Application number: 2026/91870	
What is the application for?:	Certificate of lawfulness to convert dwelling to residential institution childre
Address of the site or building:	14, Howard Avenue, Lindley, Huddersfield, HD3 3DJ
Postcode:	HD5 8TE

Type of comment: An objection	
Do you wish your comments to be published on the website anonymously?	Yes
To: Planning Department Kirklees Council PO Box 1720 Huddersfield HD1 9EL Reference: PP-14985020 / 2026/CLD/91870/W Property: 14 Howard Avenue, Lindley, Huddersfield HD3 3DJ Proposal: Lawful Development Certificate – Change of Use from C3 to C2 Dear Sir/Madam, I am writing to object to this application. I support the need for care for vulnerable people, but I believe this proposal does not meet the requirements for a Lawful Development Certificate under the Town and Country Planning Act 1990, for these reasons: 1. Use is not clearly defined It says it could be for either elderly people or foster children/teenagers – these are very different uses with different rules and impacts. You cannot confirm it is lawful when the actual purpose is not clear. 2. Important information is missing There are no details about: • Who will operate the home

Existing Site Plan

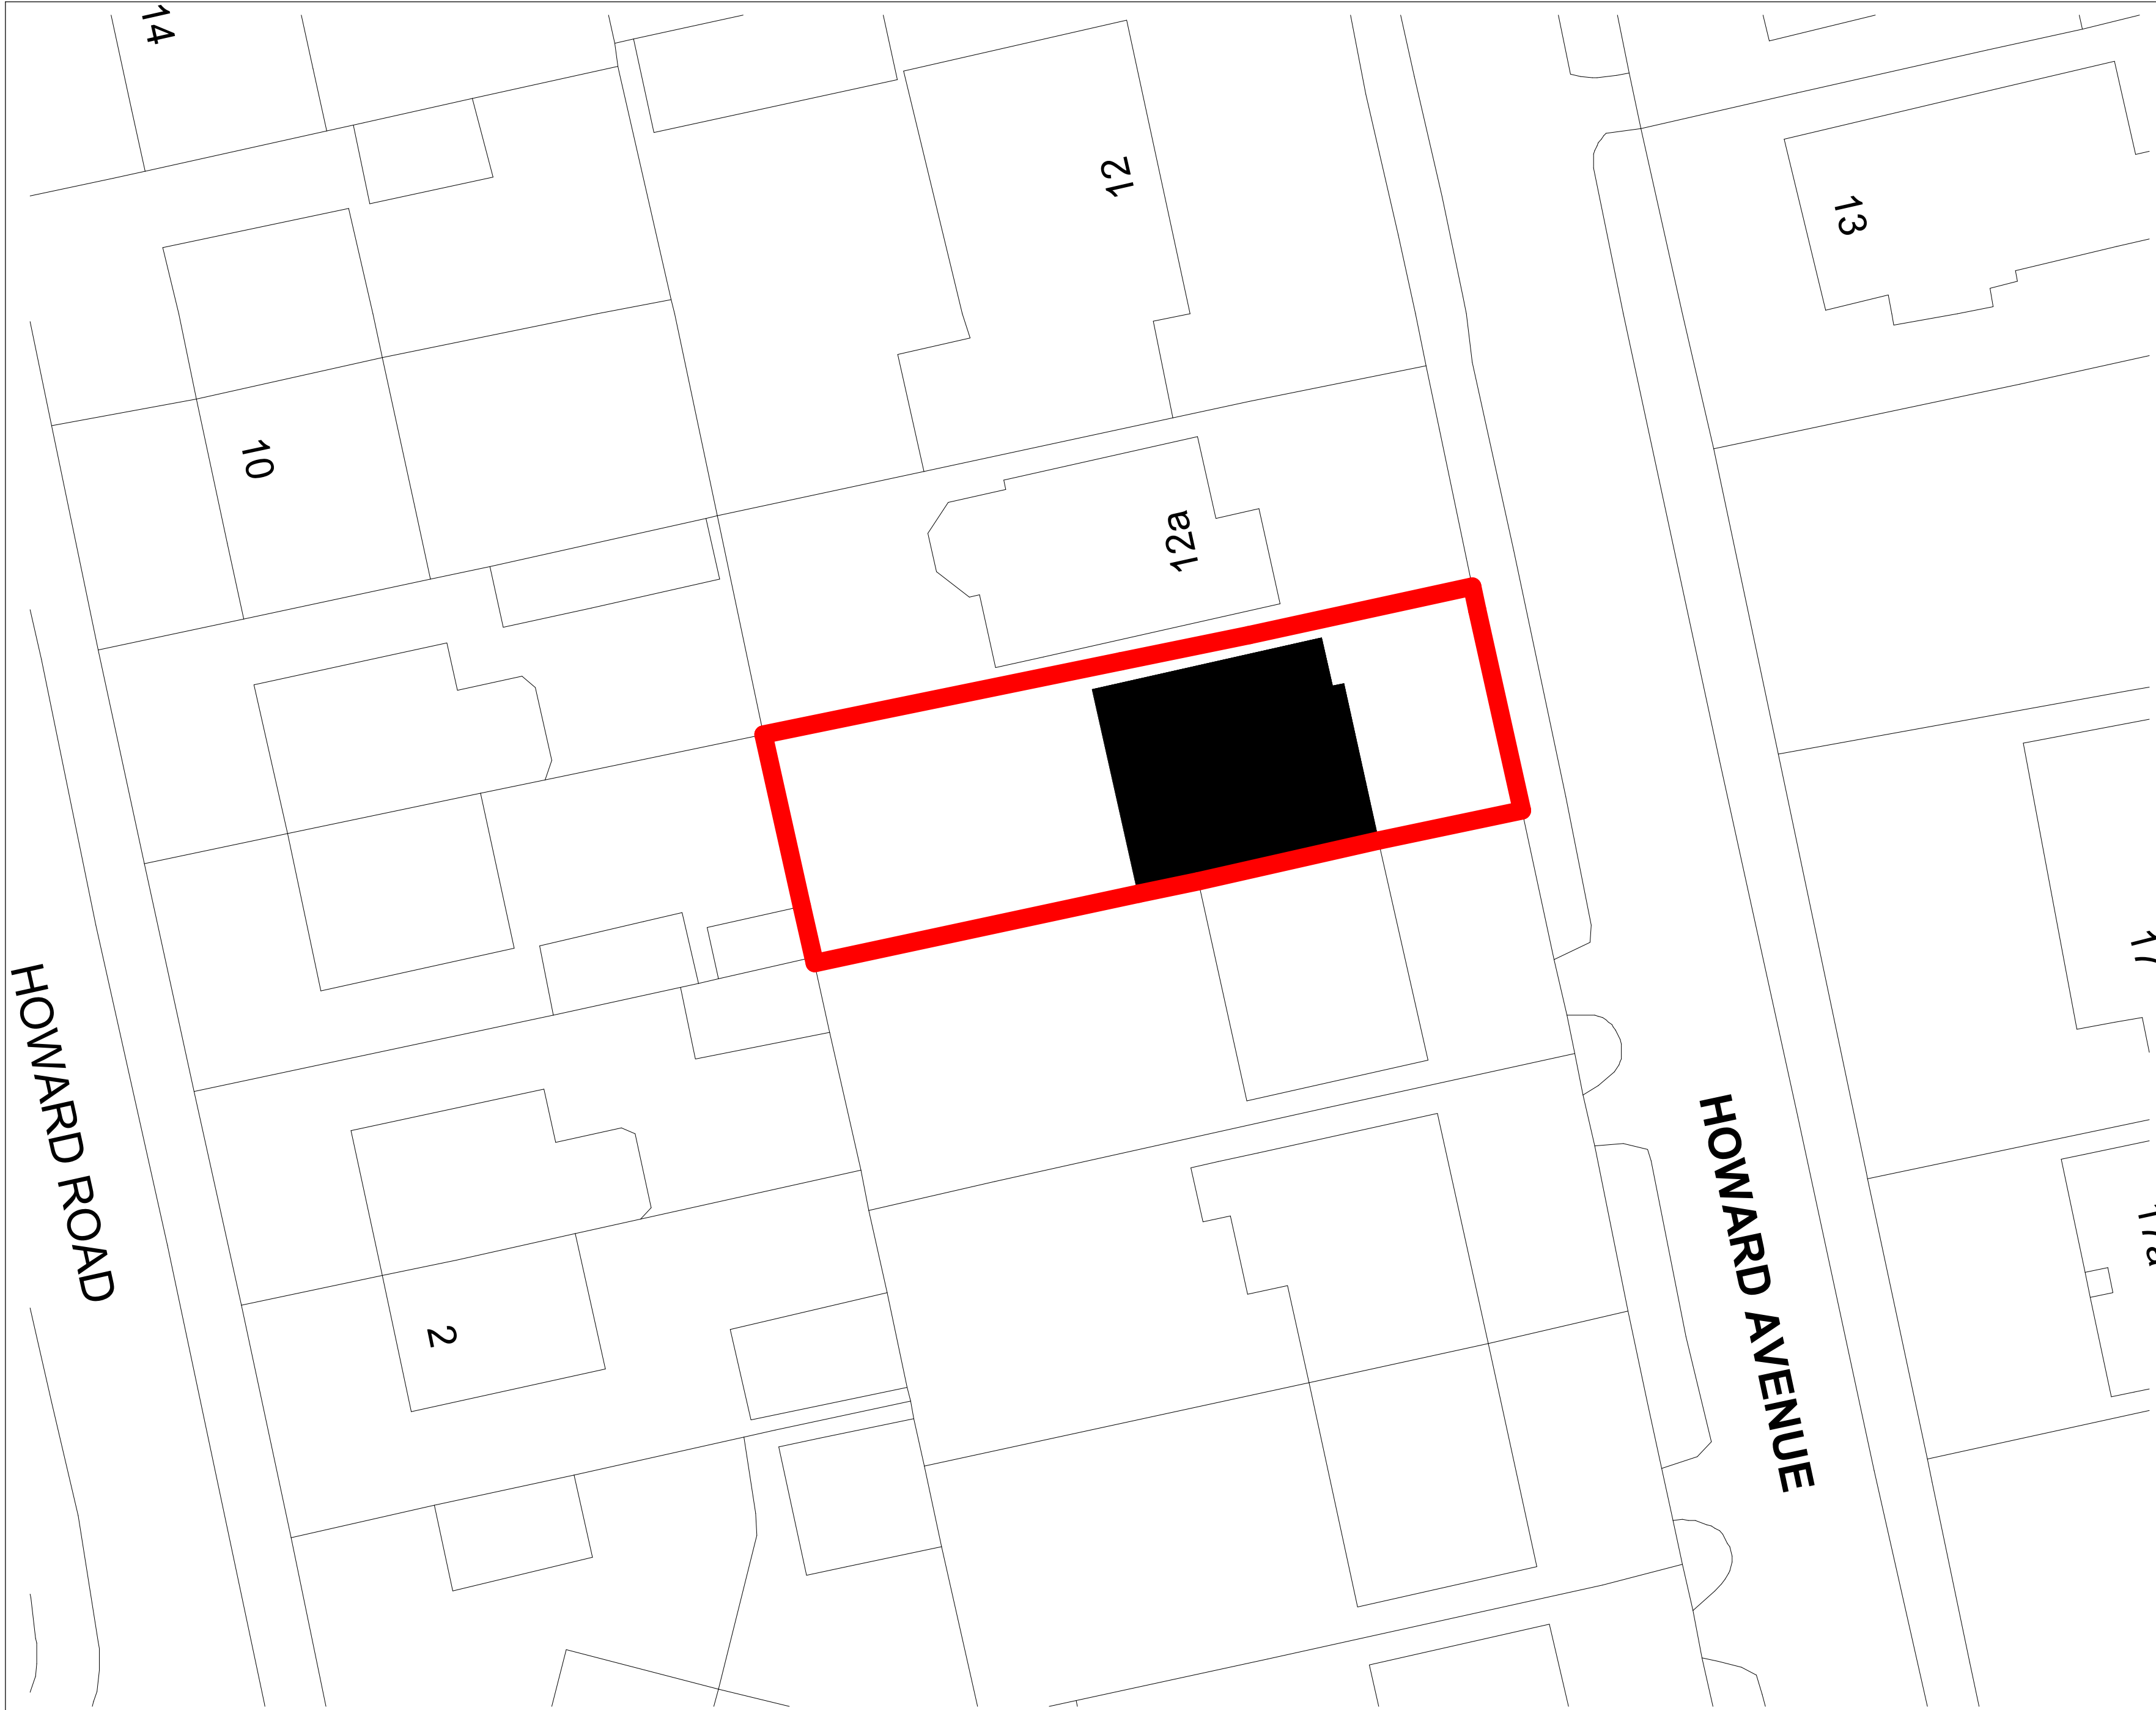
4. Parking information is wrong

It claims 3 parking spaces, but only 2 are safely usable. The third restricts access and is not practical. No evidence is provided to prove 3 spaces exist.

Khuram	
14 Howard Avenue, Huddersfield	
Proposed Floor Plan	
Project number	RAD-35-26
Date	20.05.2026
Drawn by	RA
Checked by	RA
20	
Scale	1 : 50

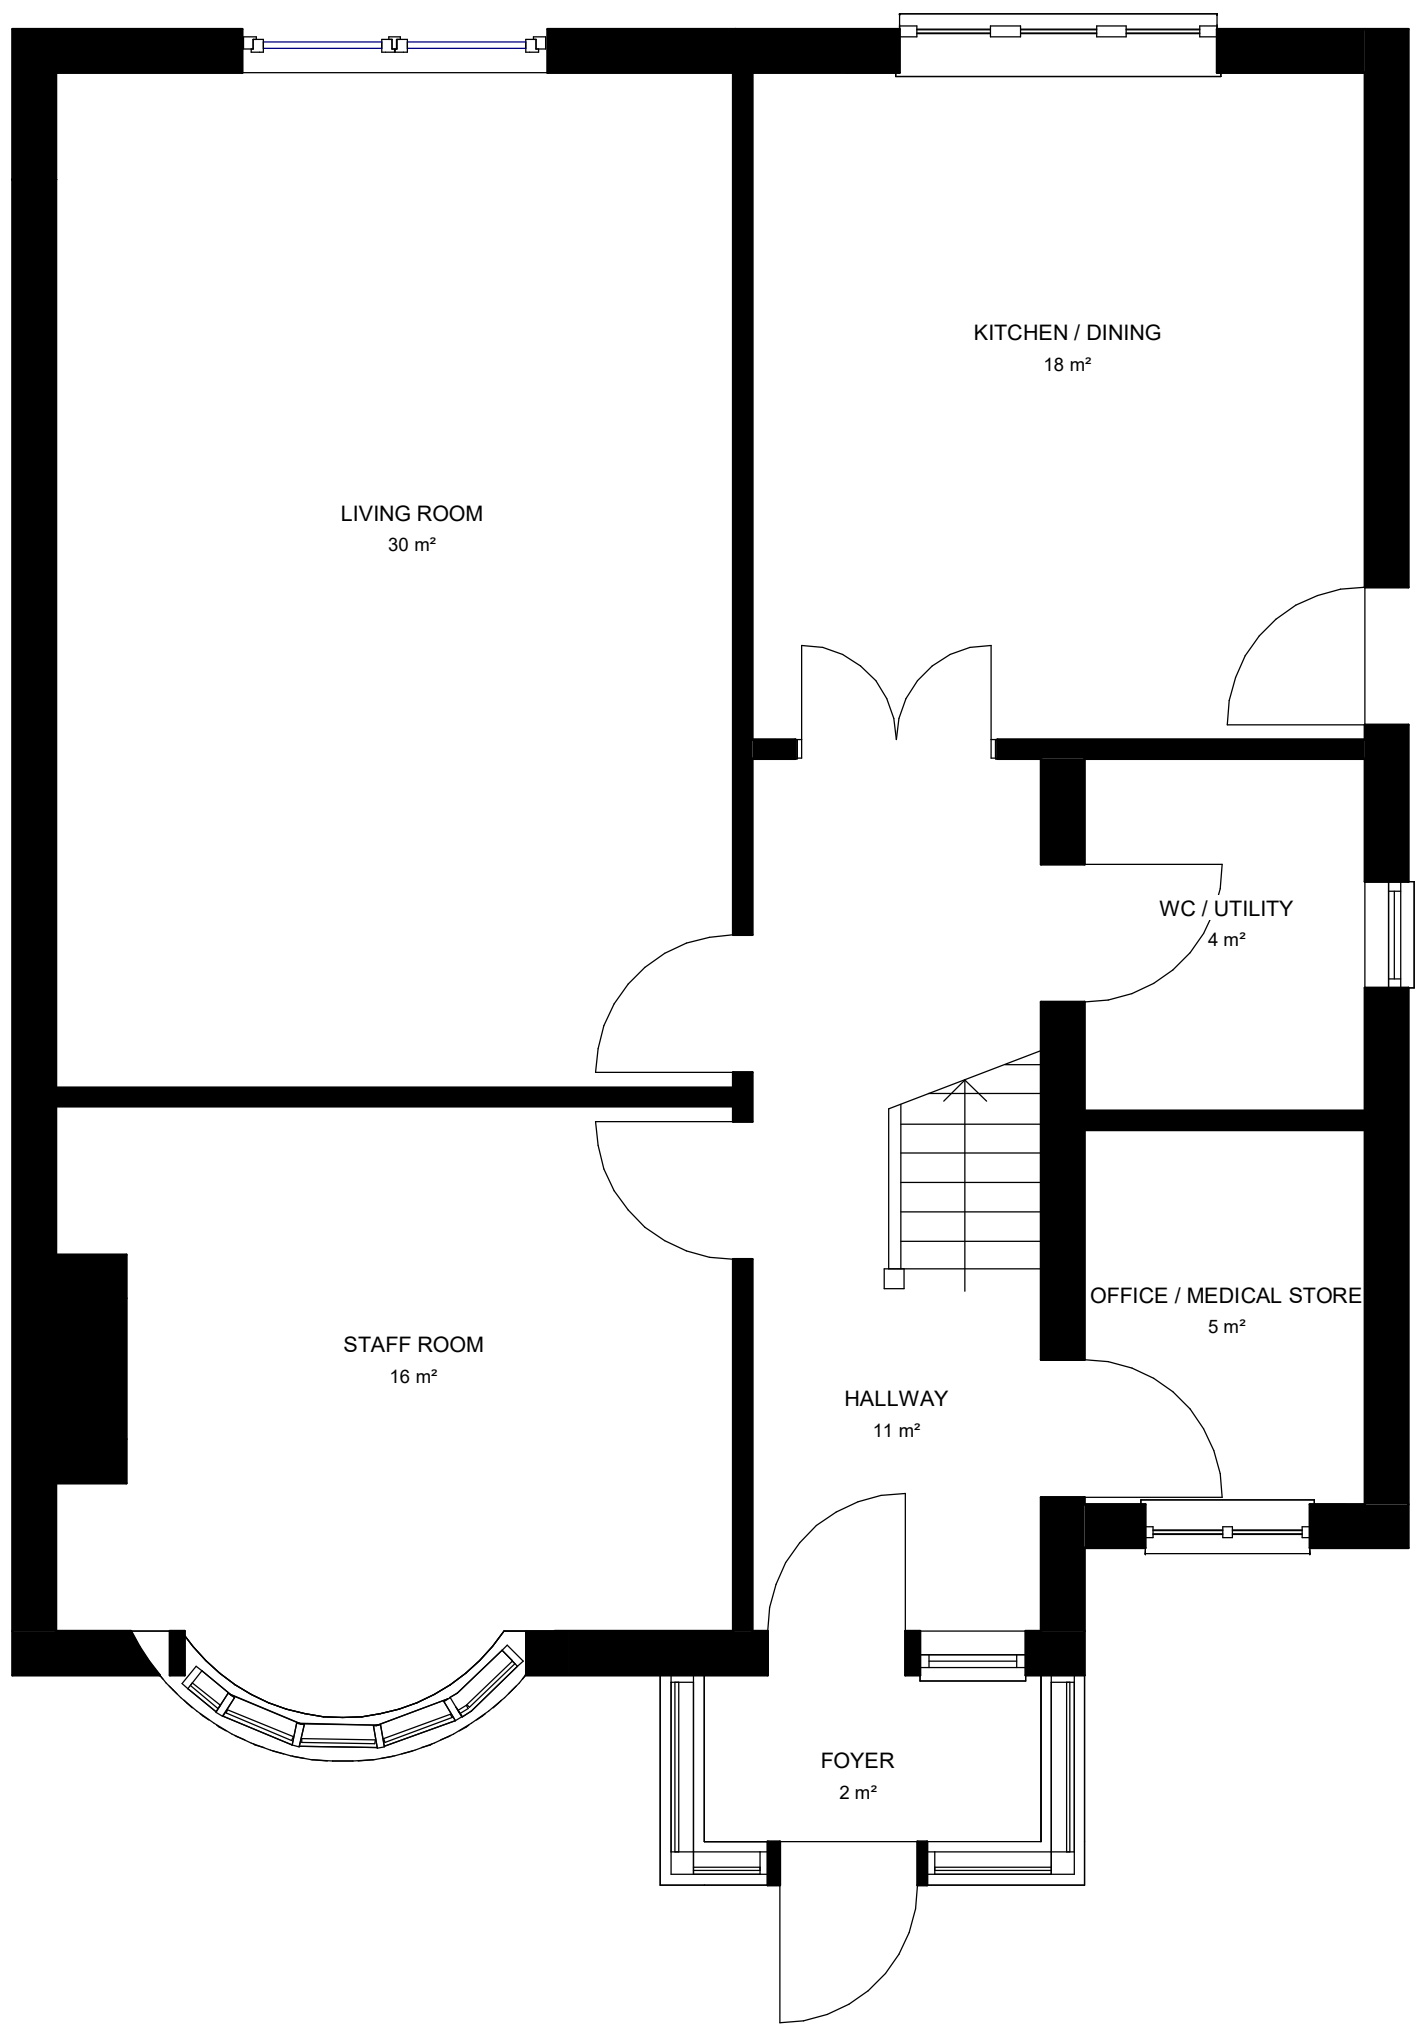
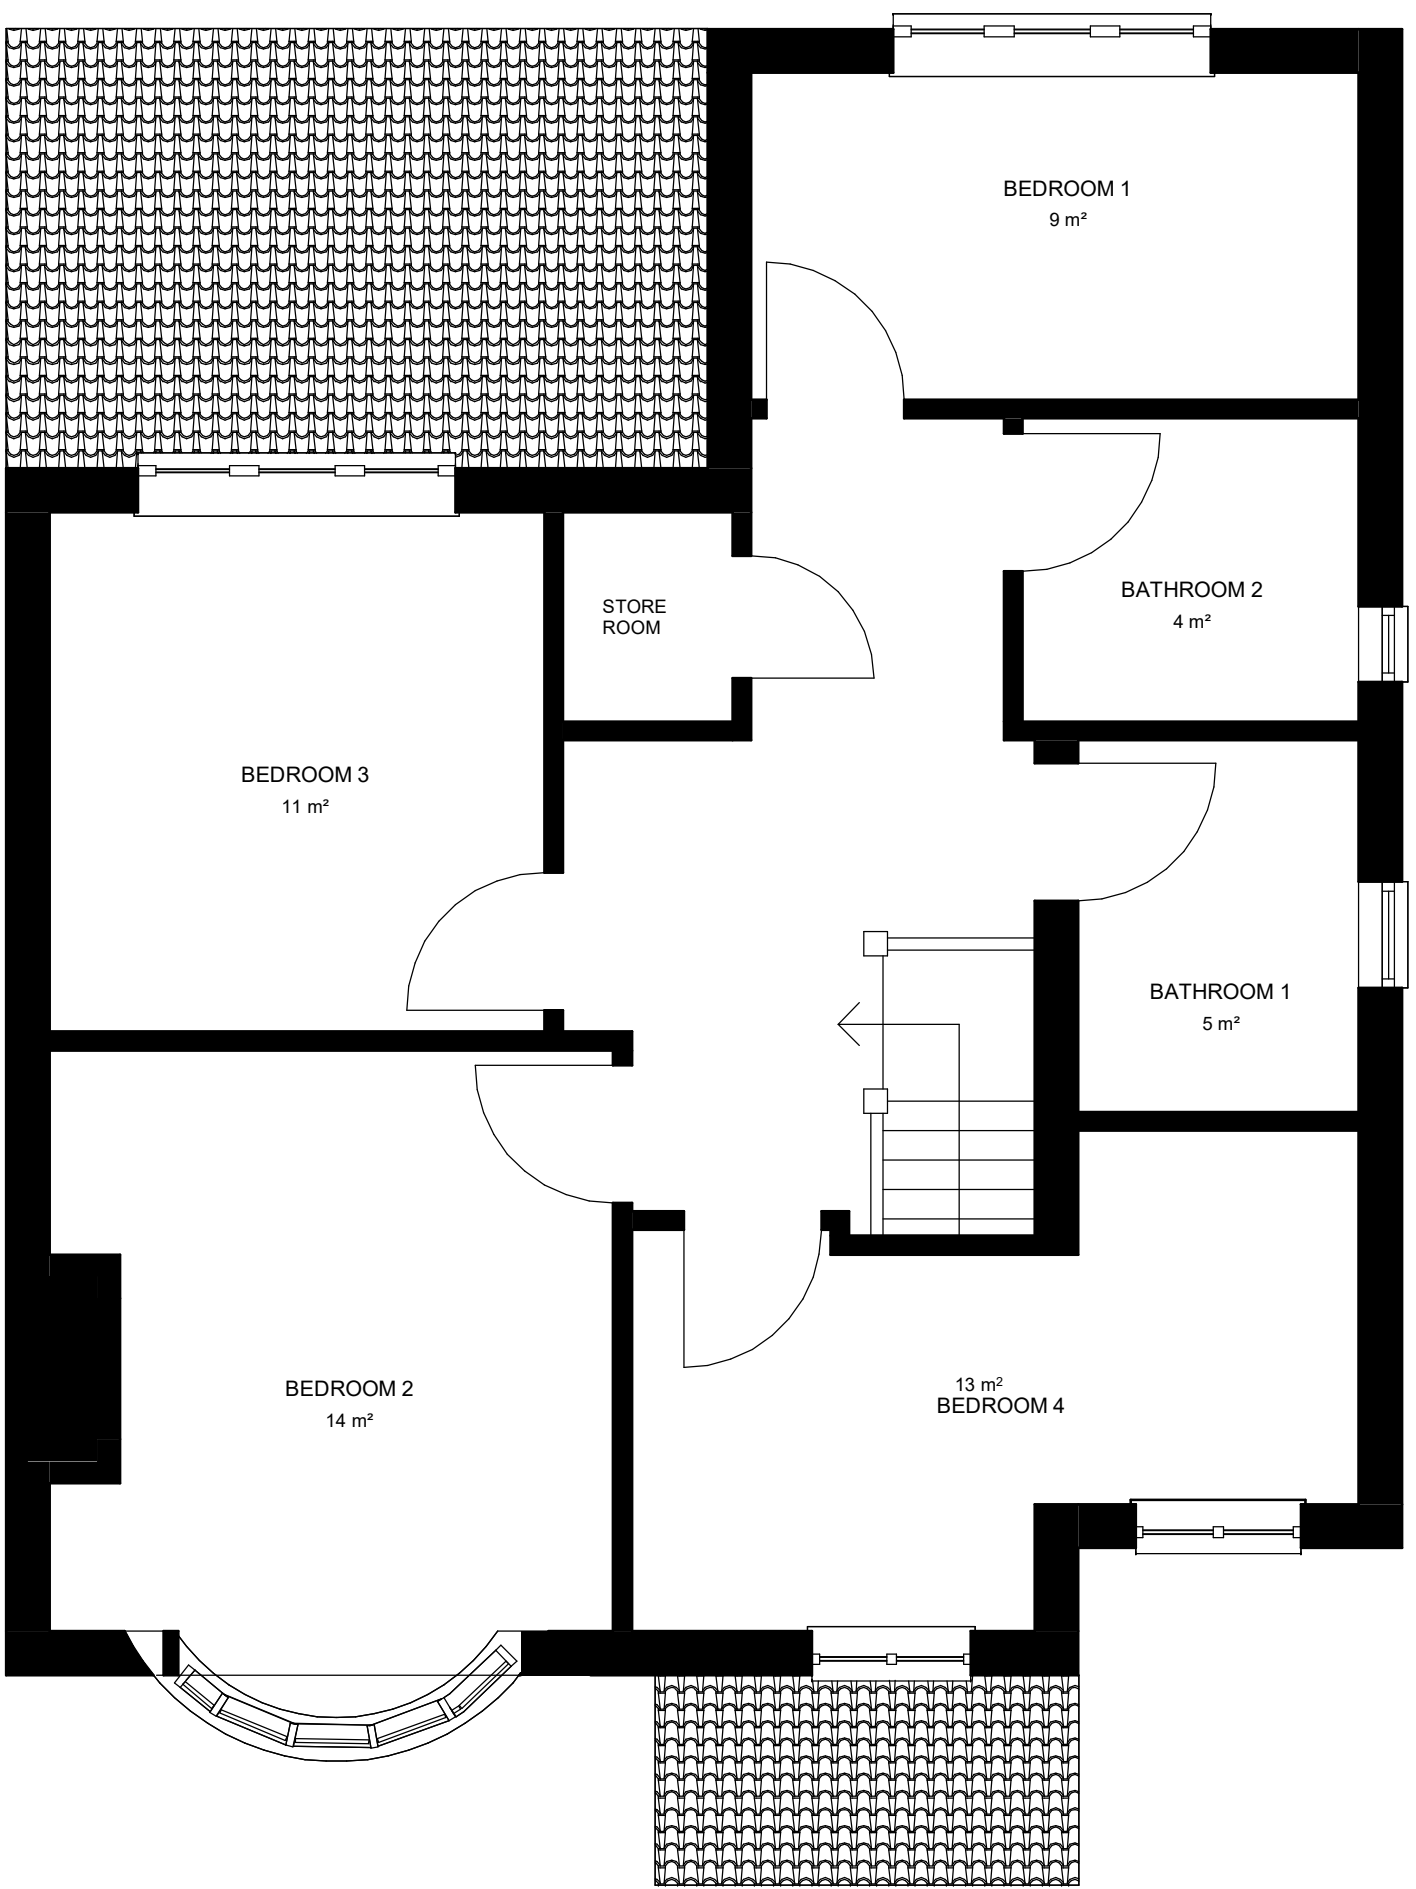
3. Layout shows a full care facility

Plans include staff rooms, offices and medical storage. This is not just a private house – it is a managed care establishment that should go through full planning permission, not this certificate route.
